Application no: H16-0907-10

Description: Change of use of residential dwelling to children's nursery (retrospective)

Location: Hillegom
Little London
Spalding
Lincs
PE11 2UF
PE11 2UF

Amendment: Amendments to parking arrangements
(dwg. no. 1947-02A)

1947-02A

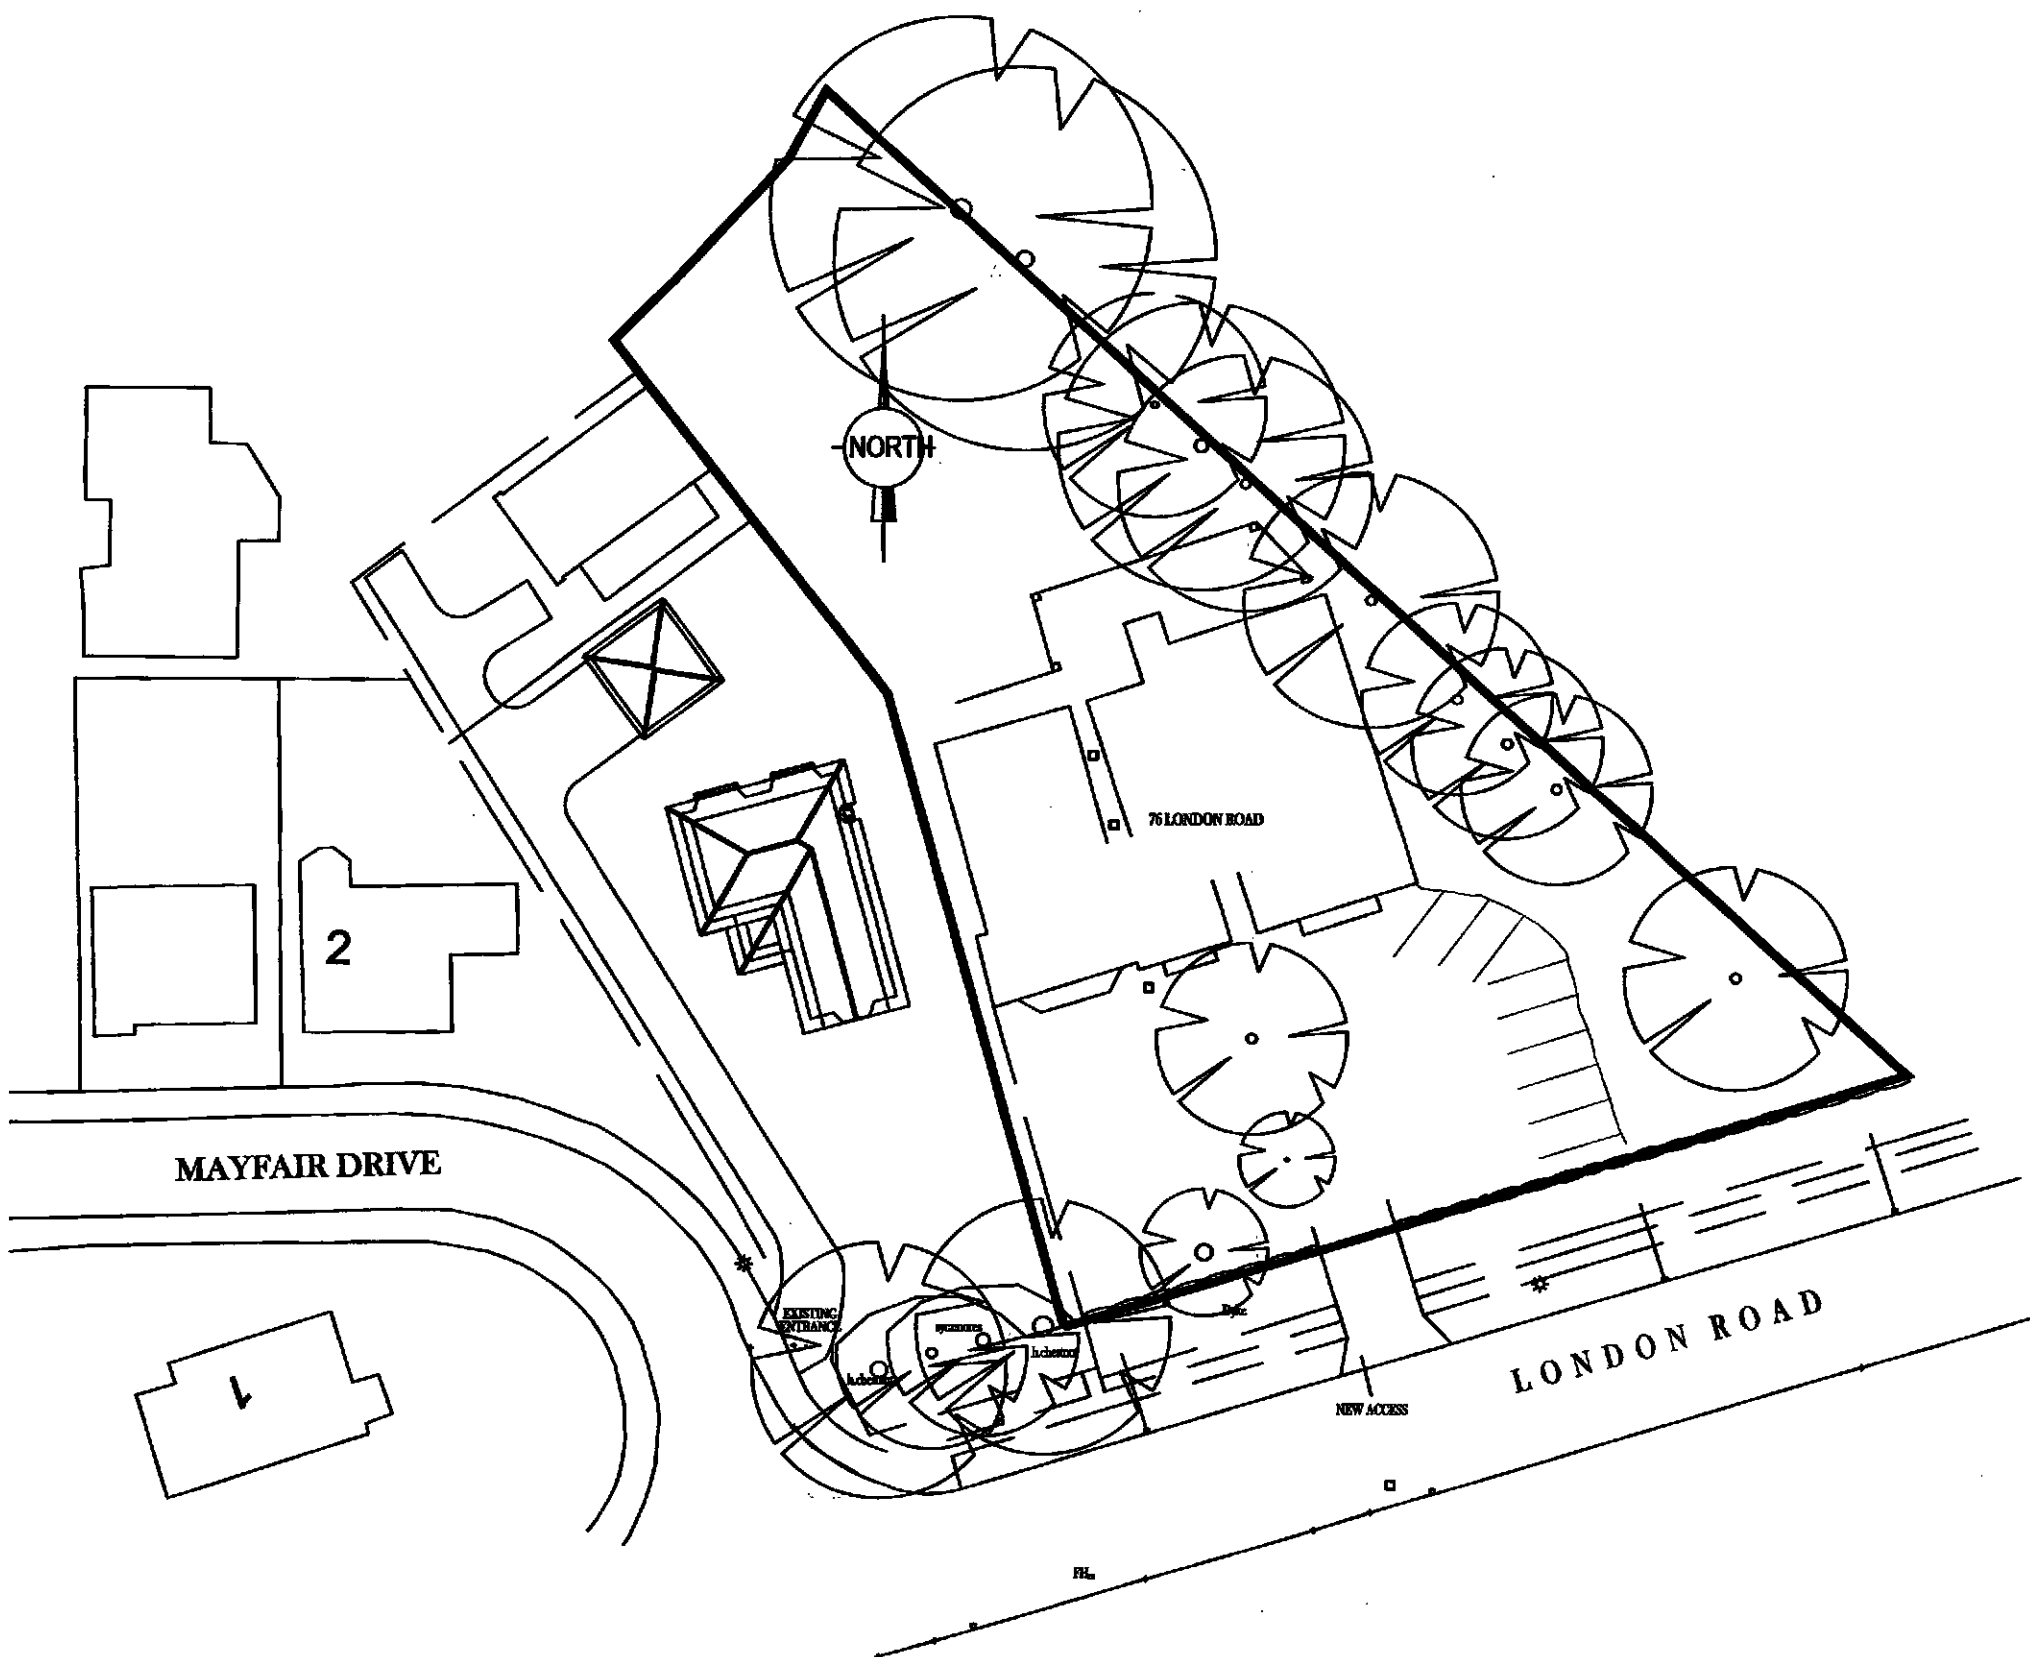
Can you also clarify the number of children that will be on the site during daytime/night time, what the peak collection/pick-up/drop-off hours are, and can you also mark up a copy of the block plan to show proposed parking/turning arrangements (the recently approved access did not show these details, and in any event was approved in connection with the previous residential use).

Amended drawing attached as requested.
